Re: Champs Fresh Food
8909 US 401
Fuquay-Varina, NC 27526
BCOM2311-0004

The application and plans for Champs Fresh Food, located at 8909 US-401, Fuquay-Varina, have been reviewed and are disapproved for the following:

Jamie Turlington, REHS
Harnett County Environmental Health
Harnett County Health Department

PROPOSED LAYOUT
SCALE: 1/4" = 1'-0"

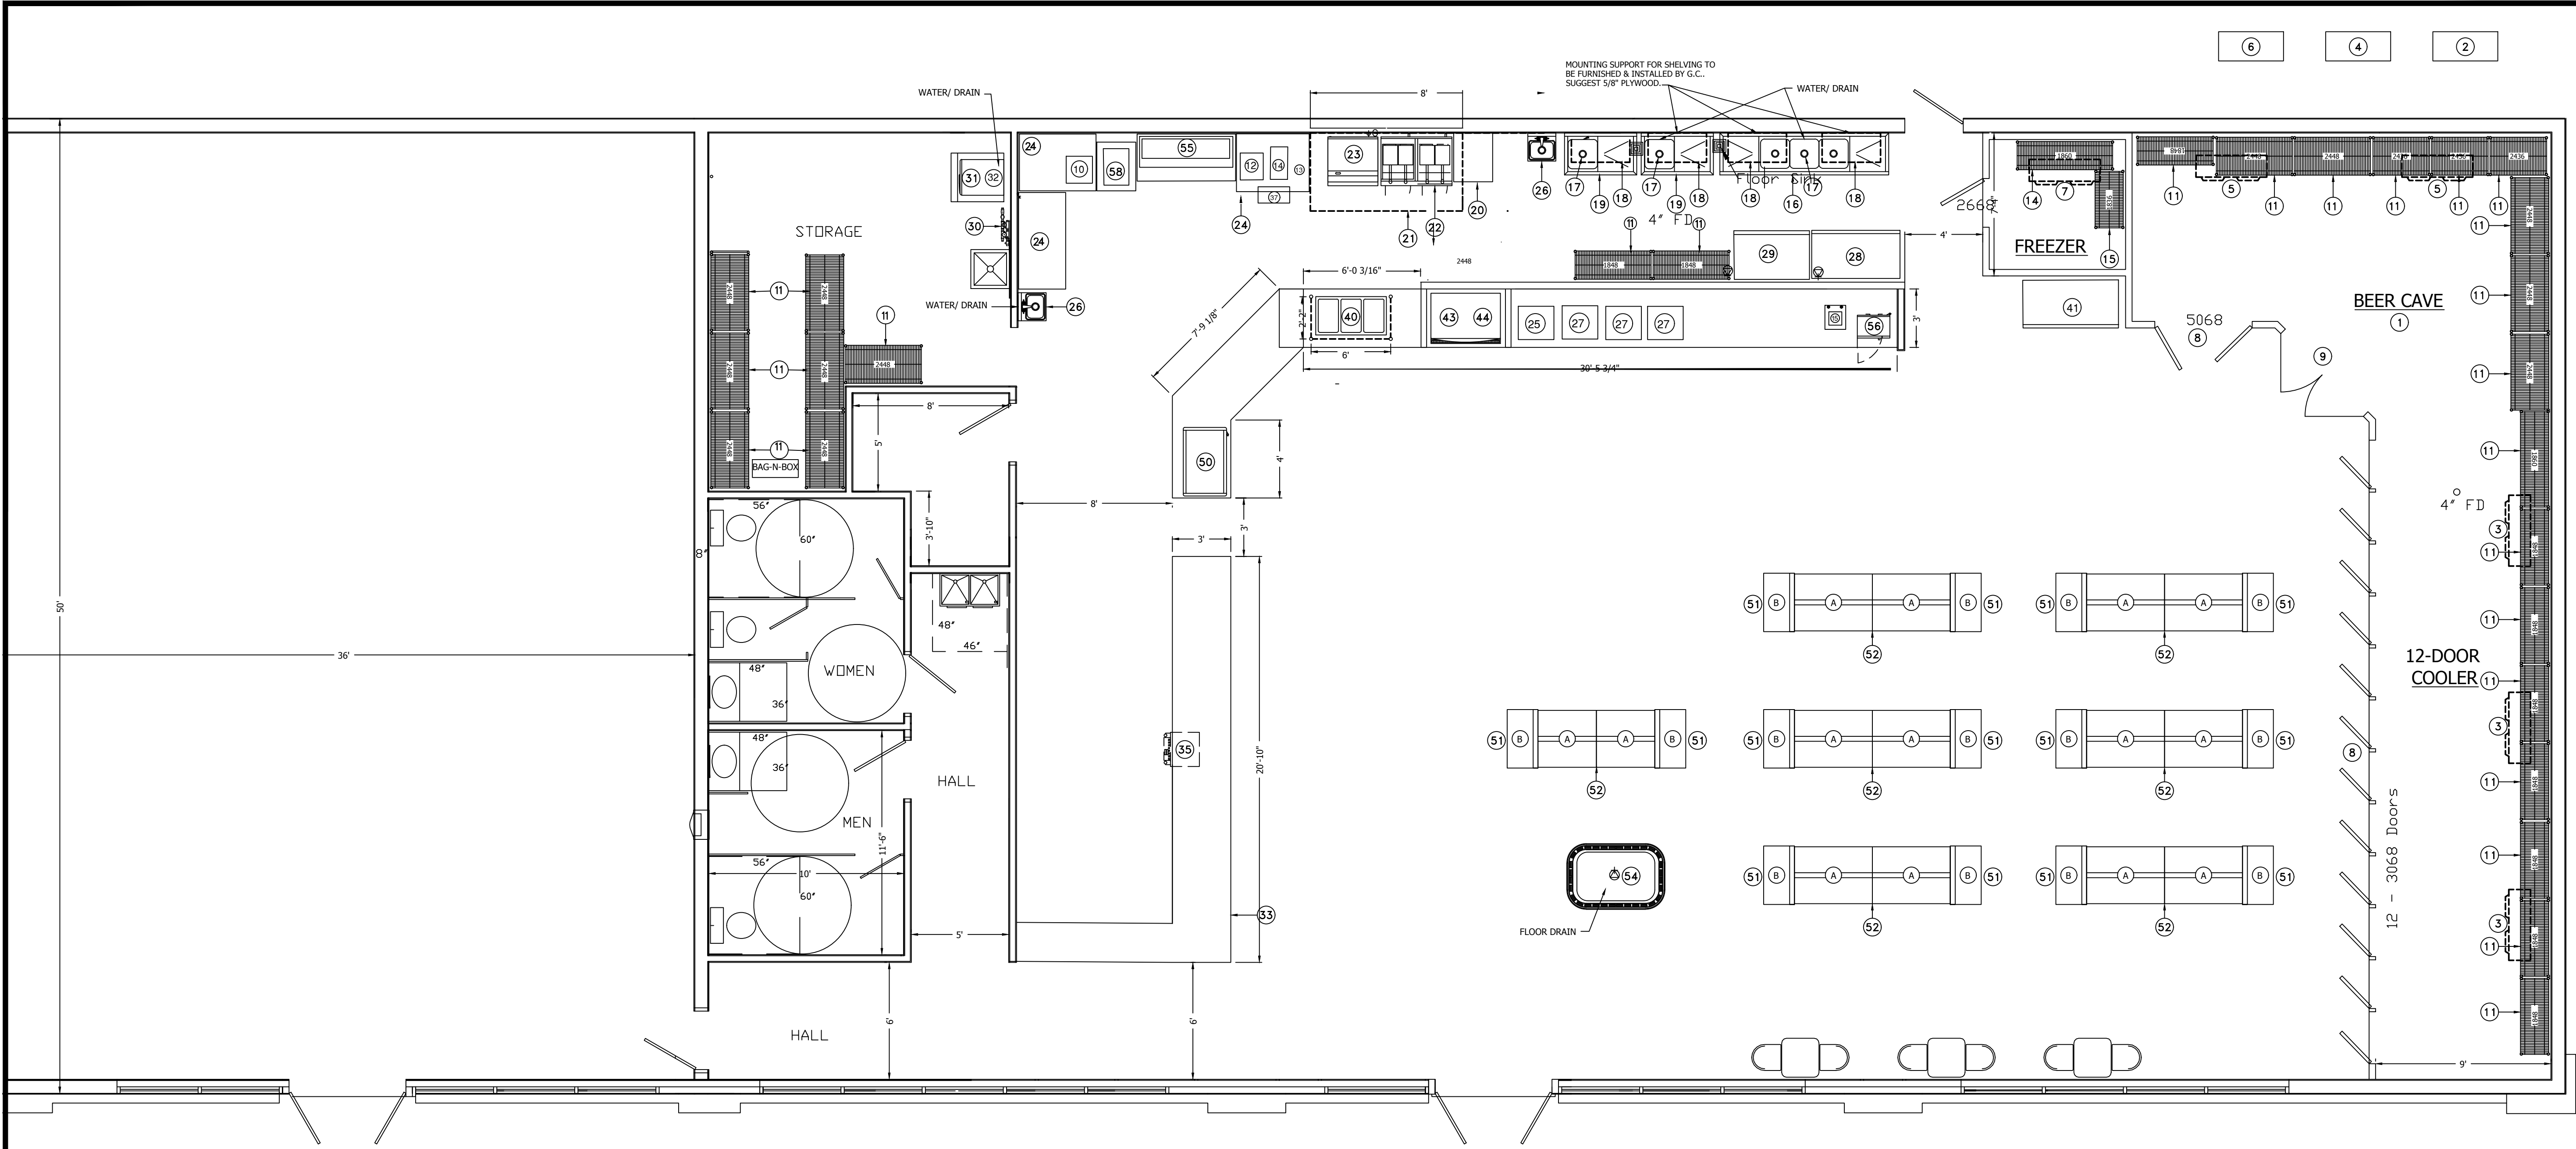
- 3-Provide equipment specification sheets for all food service equipment.
- 4-Provide an additional handsink near the food prep and dishwashing areas.
- 5-Provide additional reach-ins, freezers and refrigerators in the kitchen.

- 6-The plans indicate the public will have access to the walk in freezer in the kitchen. The public must be excluded from areas where food is stored for the kitchen. The freezer cannot have access to the public.

- 7- Indicate the proposed use for the hot holding wells on the front counter and for the heated display case. Describe the type of foods stored in these units.

- 8- Describe proposed use for room off of dry storage room in the back of the kitchen.
- 9-All equipment on plans must have a corresponding equipment specification sheet. Some equipment on plans is not labeled with a number and is not listed on equipment list. It appears there is a sink next to the microwave on the counter. Label and indicate proposed use.

- 10-Describe the barriers on either side of the food prep sink. Permit conditions will be placed on the permit, limiting the operation to only use the prep sink for the preparation of one type of food. The single prep sink will be limited to vegetable prep only and all meats must come in ready to cook.
